SUBJECT: SFD2309-0088
SINGLE FAMILY DWELLING

Here are the results of all Inspections located at **12583 MCDUGALD RD:**

Truss Placement Plan
SCALE: 1/4" = 1' 0"

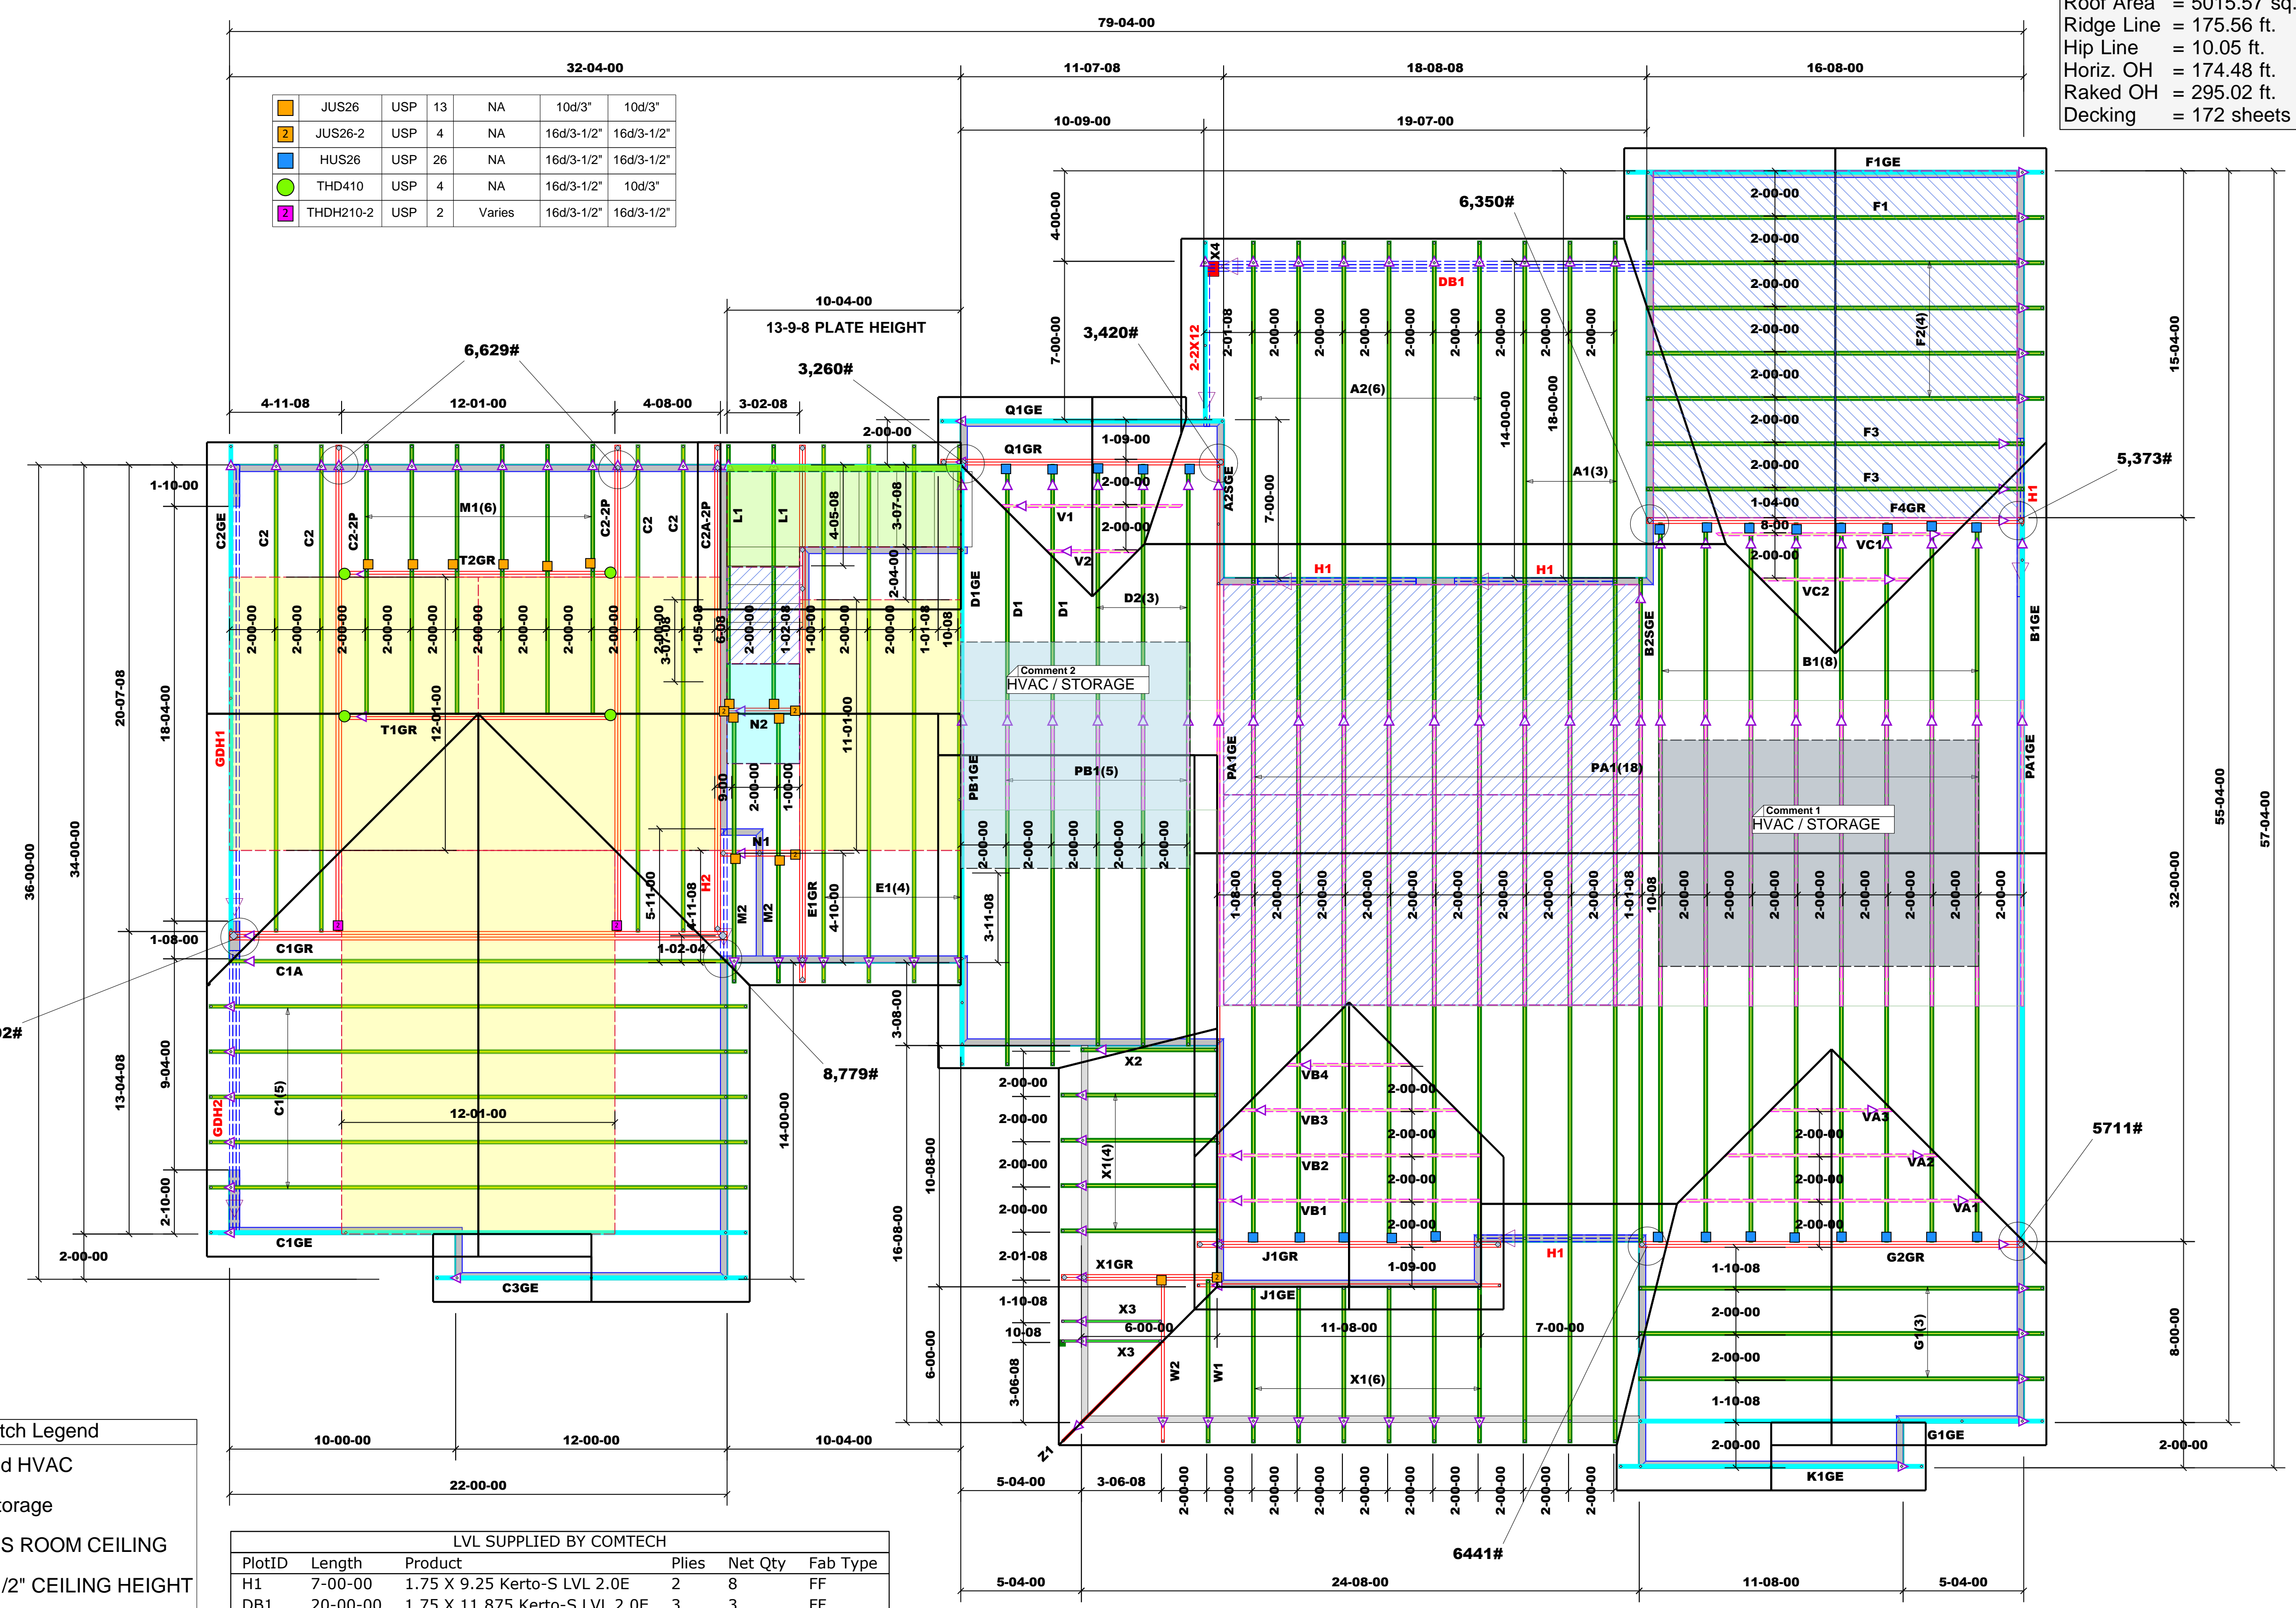
12. Seal all holes in air Barriers in master bedroom over bathroom door
13. Replace all short nails in roof truss hangers in master bedroom and bathroom and front bedrooms with correct size nails throughout house including upstairs

24. Rafters cannot be wider than ridge beam upstairs in roof framing
25. Need repair letter for cut trusses in stairway
26. Need 10 psi on gas line test
27. SFD2309-0088
